Grindleton Parish Council

**RE: Consultation on planning application 3/2022/1181 – Cherry Hall, Main Street,
Grindleton BB7 4QT**

Drawing Title
Proposed Plans, Section A-A and Elevations

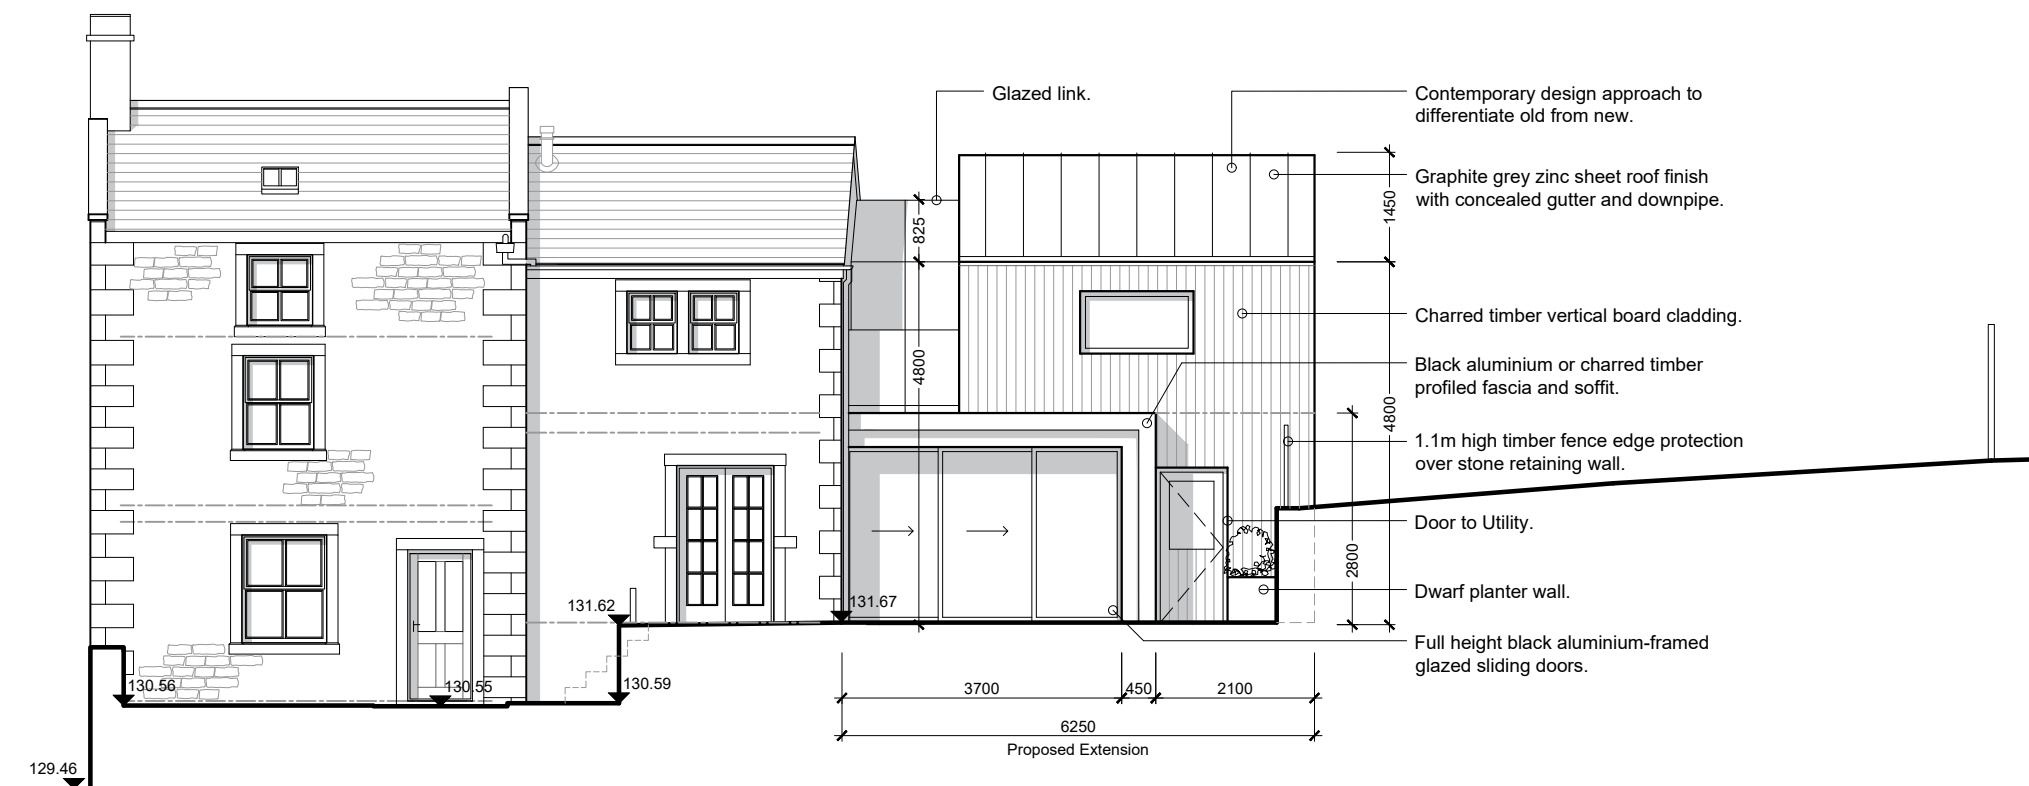
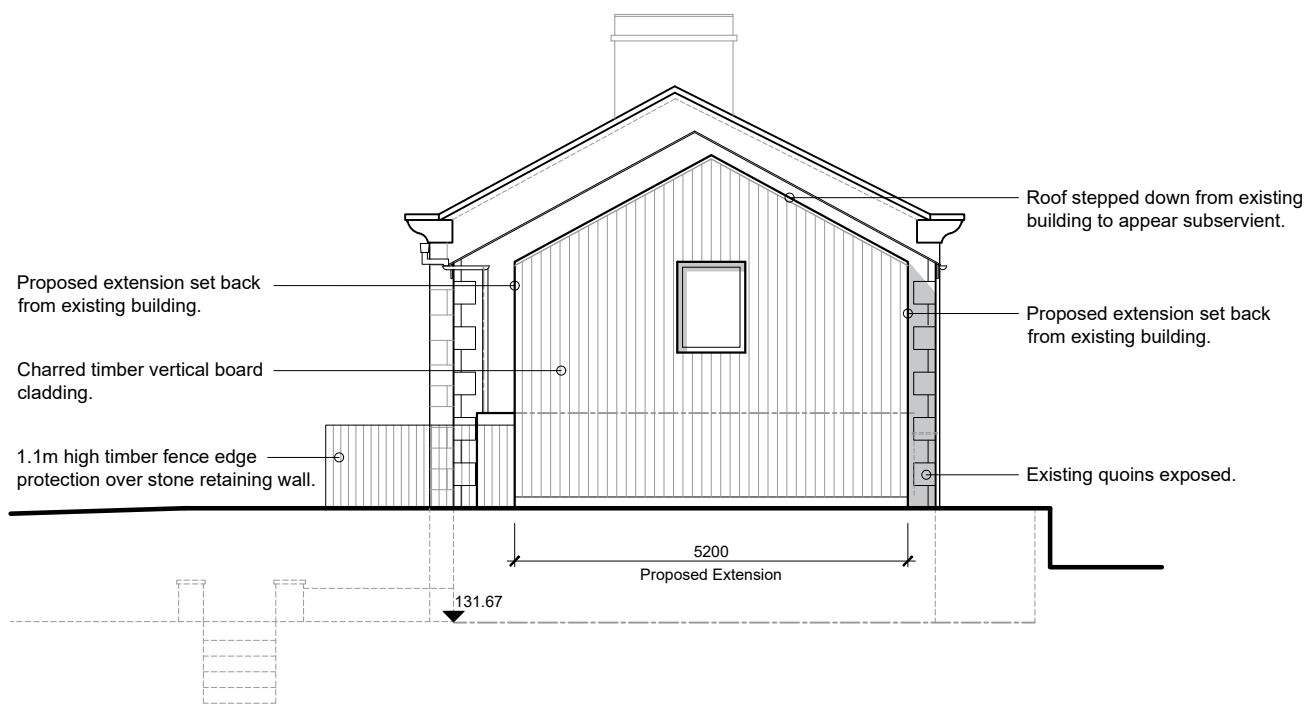
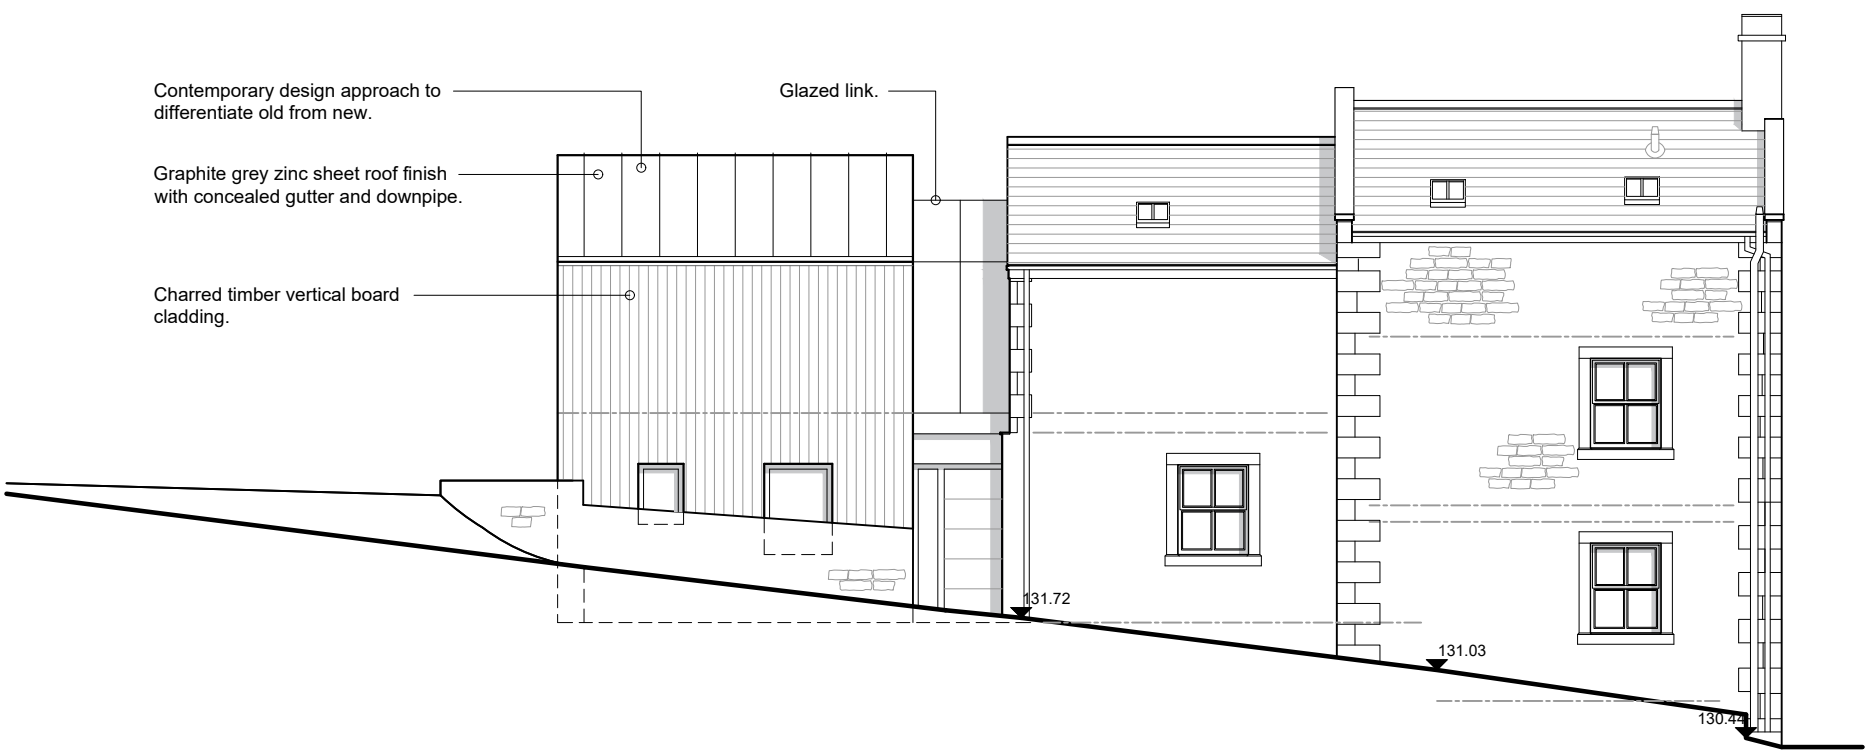
It is fair to say that this particular application has caused some division amongst Parish Council members, with no real consensus being reached. However, during the discussion, the view has been expressed that the proposed design of the extension to Cherry Hall may be somewhat incongruous when set against its immediate village surroundings. Members note

that some of the proposed materials (eg zinc sheeting roofing and charred timber cladding) are of a contemporary nature, which may appear out of place when compared with other Main St properties, where a more traditional design is predominant.

For ease of reference, an extract from the proposed plans illustrating their contemporary nature is reproduced below:

In light of the proposed modern design, members would seek reassurance from the Local Planning Authority that it has assessed the materials to be used against the relevant criteria for an Area of Outstanding Natural Beauty.
